Please ask for: Ms Iqraa Malik
Email: iqraa.malik@terraquest.co.uk
Telephone: 0121 234 1390
Our Ref: PO/11/21/HH
Your Ref:
Date: 13th October 2021

Application for Planning Permission for Works or Extension to a Dwelling

Development: Erection of single storey side and rear extension, replacement garage building following the demolition of existing rear extension. Repair and reconstruction of the roof structure, associated landscape works and external alterations.
(This application may affect the setting of a listed building)

Location: St Johns Cottage Poling Street Poling BN18 9PS

SITEPLAN 1:100

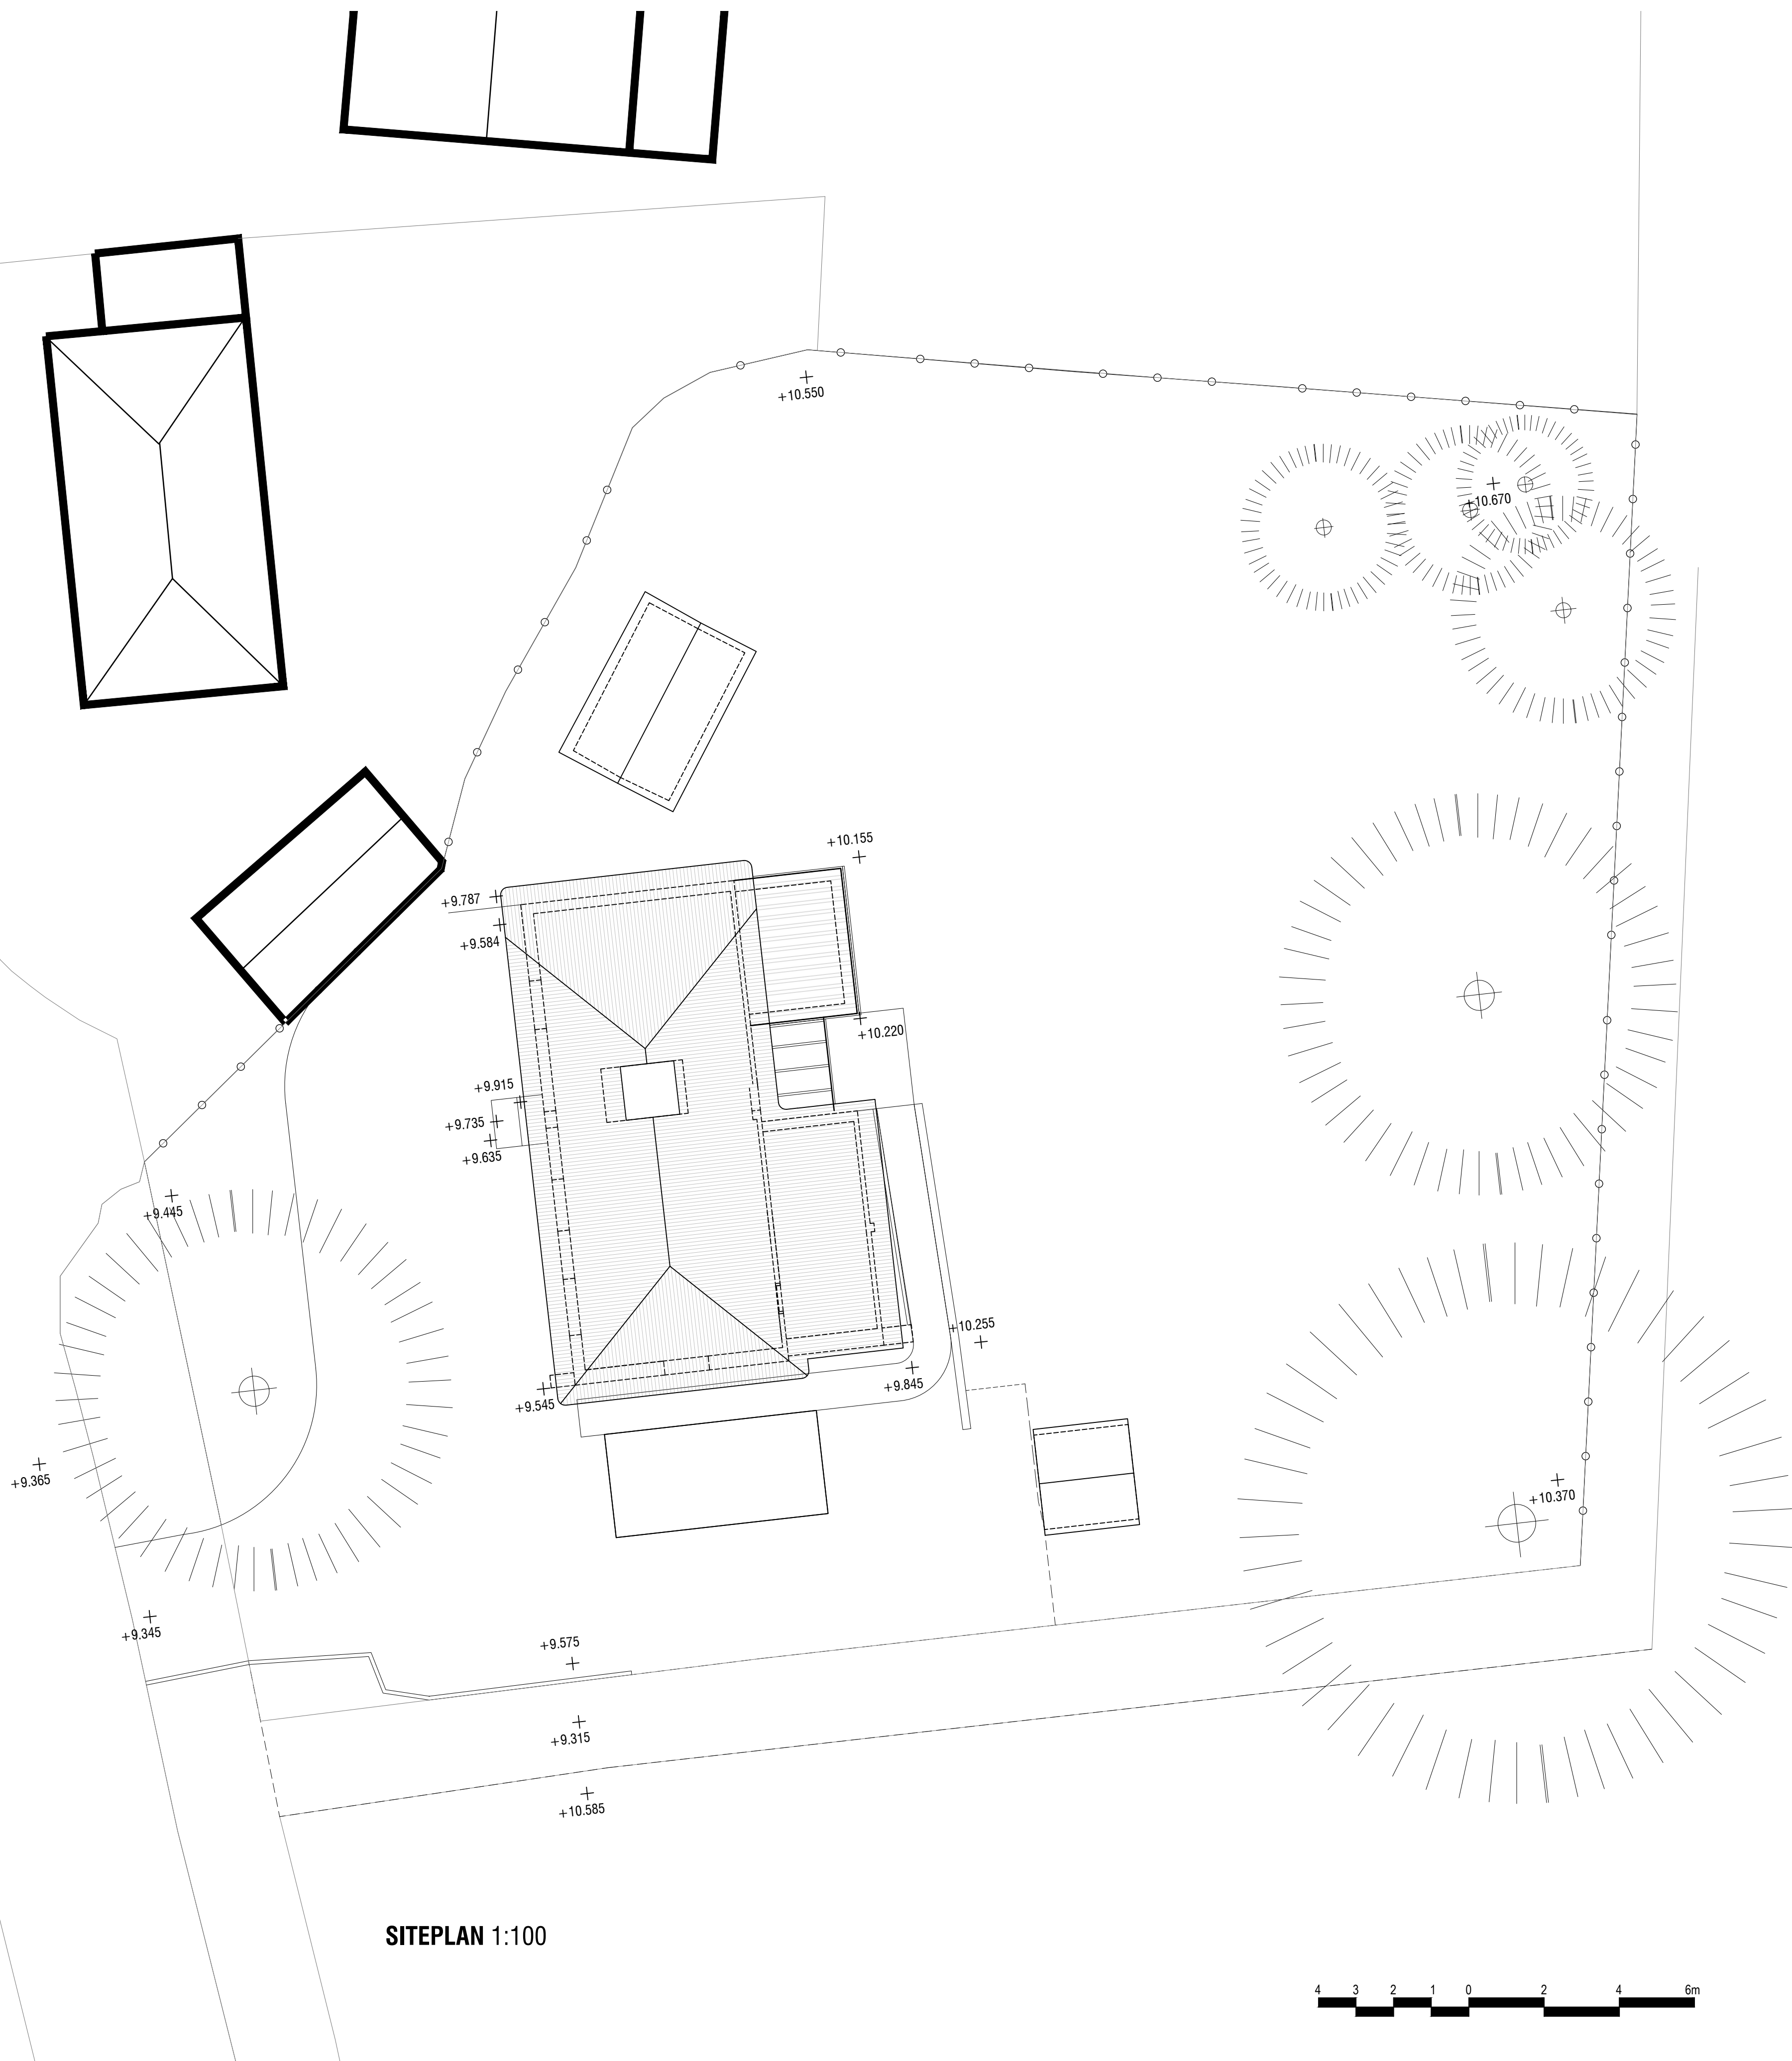
Block Plan

You are required to have dimensions from the proposed extension(s) to all site boundaries. Please amend.
